Consultation Response from: KC Environmental Health (Pollution & Noise Control)
2021/93305 - 61-65 New Street, Huddersfield, HD1 2BQ
Change of use and conversion of existing buildings, erection of split-level seven storey extension comprising four-storey stairwell, five-storey roof-top tower block and enclosed courtyard to form 31 dwellings and sub-division of the retail unit forming 61-63 New Street (Listed Building within a Conservation Area)
**Responding Date:
23 September 2022**
**Responding Officer:
Mohammed Nasim**
**Responding Ref:
WK202228335**
Comments
Noise

Figure 2.0 – Façade Colour Grouping

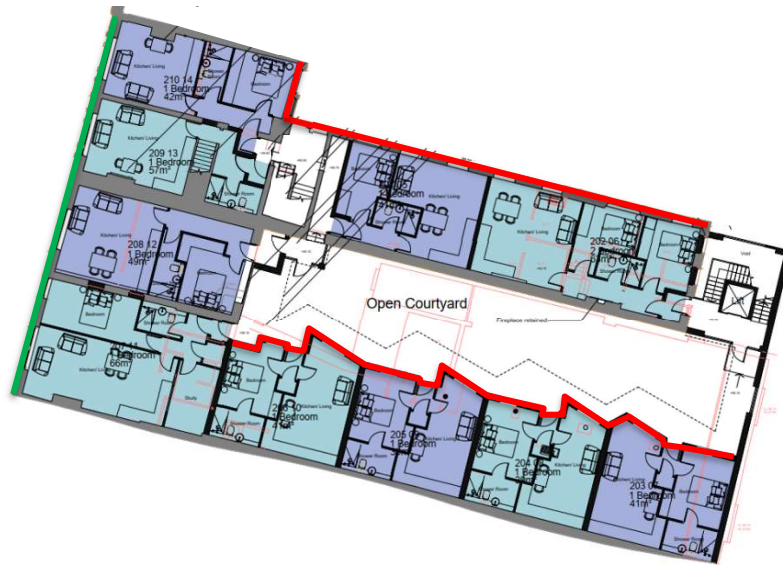
In order to correctly specify the required sound reduction, the façades have been divided into two colour groups: red and green and appropriate models of glazing and ventilation for each façade colour are shown in tables 4 to 8. Secondary glazing and double-glazing options have been given for both façades as it is thought the new extension to the building is likely to have double-glazing installed. This will need to be stated.
